APPEAL COMMENTS

EXPP: 0029/22 (Section 5 Declaration Application)

BORD PLEANALA REF: ABP-312927-22

LOCATION: Ambassador Theatre, Parnell Street, Dublin 1, D01 2243

Figure 2a. Coade Stone decorative frieze to the rotunda theatre showing Bucranium and roundel.

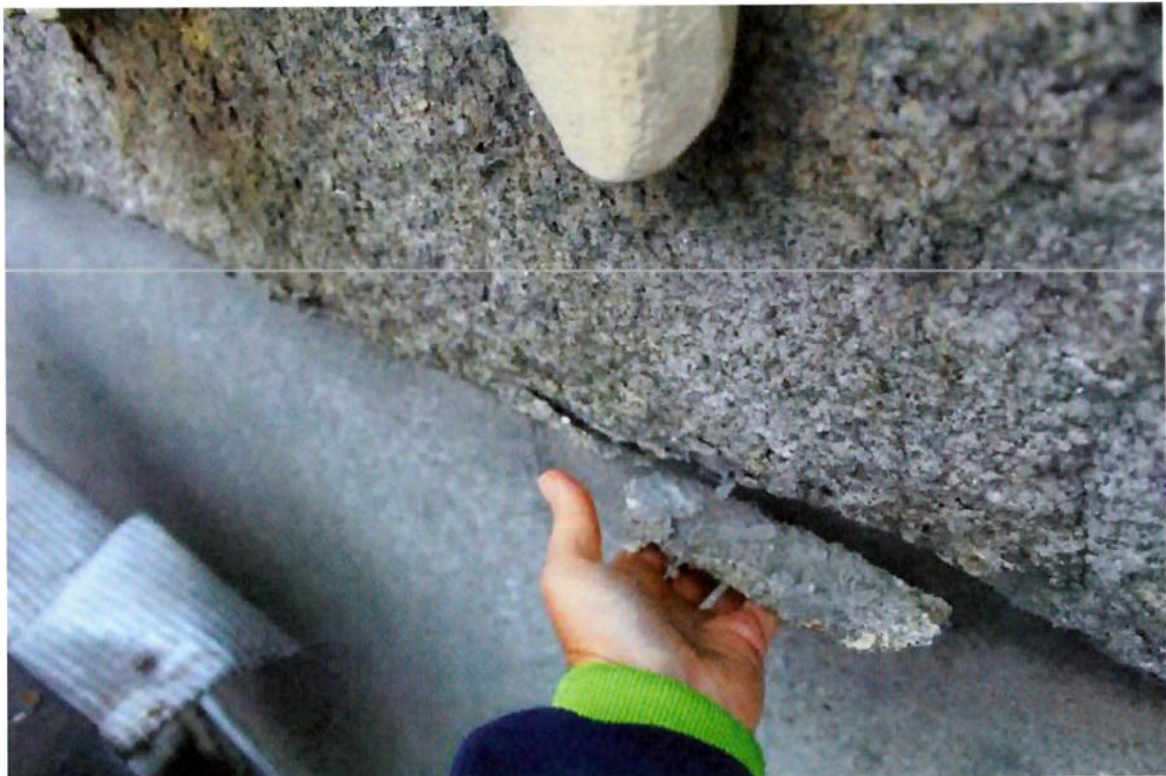
Coade Stone- It is proposed to replace a number of missing elements to the Coade Stone Bucrania frieze, to the drum of the building. It is understood that the Coade Stone Bucrania frieze, represents the only known example of its kind in Ireland and one of the finest examples of this technically innovative artificial stone in existence. The specification provided is general in nature and it has not been demonstrated that a specialist with proven expertise in the repair/manufacture of Coade Stone was involved. Detail of the proposed repairs to the highly significant Coade stone frieze, have not been clearly specified and the proposed work has the potential to materially affect the character of the protected structure and as such these works are not considered exempted development.

Coade Stone- It is proposed to replace a number of missing elements to the Coade Stone frieze. It is not clear if detached sections, indicated to adjacent roof areas have been considered for reassemble and reinstatement. As such, the applicant has not provided clear justification that the replacement of these elements over their repair and reassembly is justified. Furthermore, it is not clear how it is intended to repair sections of the swags where fragmentary parts have been lost. The method statement does not expand on how localised repairs (as opposed to the casting of complete replacements) are to be achieved. Best practice would call for the Coade stone to be cast and then worked down to form replacement elements, with any shaping undertaken on the newly cast matching material and not the original. Notwithstanding the fact that the agent proposes that works *shall* be undertaken by a specialist Coade Stone manufacturer, the specification provided is general in nature and it has not been demonstrated that a specialist with proven expertise in the repair/manufacture of Coade Stone was involved. Detail of the proposed repairs to the highly significant Coade stone frieze, have not been clearly specified, the proposed work has the potential to materially affect the character of the protected structure and as such these works are not considered exempted development.

Figure 15 Arcade link to the Rotunda Hospital with the Rotunda Theatre building behind. Left had side was subject to a cleaning trial by Thomann-Harry. This has proved to be too severe and we do not recommend using it.

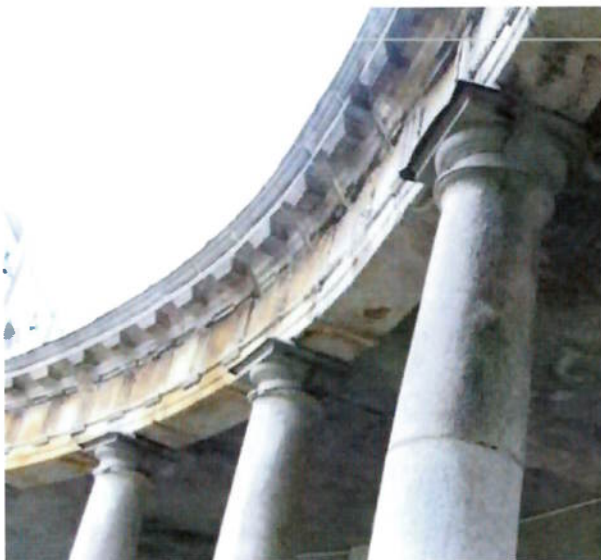
Cracking of Granite & Rendered Elements- The conservation report highlights a number of potential structural issues to include: cracking to the granite soffit of the arcade (fronting the Rotunda carpark); cracking to and below the cornice to the east elevation; as well as the displacement of a corner section of stonework to this facade. The submission confirms that the cause of the cracking is unknown and although the applicant indicates that a conservation structural engineer *shall* be appointed to investigate, it is understood that assessment of the property by a suitably qualified conservation engineer has not yet been undertaken. No structural assessment has been provided as part of the submission and the structural impact of the works in these areas has not been clearly detailed or addressed. The Architectural Heritage Protection Guidelines for Planning Authorities state that '*Where alterations are proposed to walls or other structural elements of a protected structure, the planning authority should be satisfied that the proposals are based on a proper knowledge and understanding of the existing structure*' (2011, pg.116). Insufficient information has been submitted which would demonstrate that the proposal would not materially affect the character of the protected structure and as such the proposals would not be considered exempted development. *Note: Site investigations should be carried out in discussion with the Conservation Section and may require separate consents/section 5 approval.*
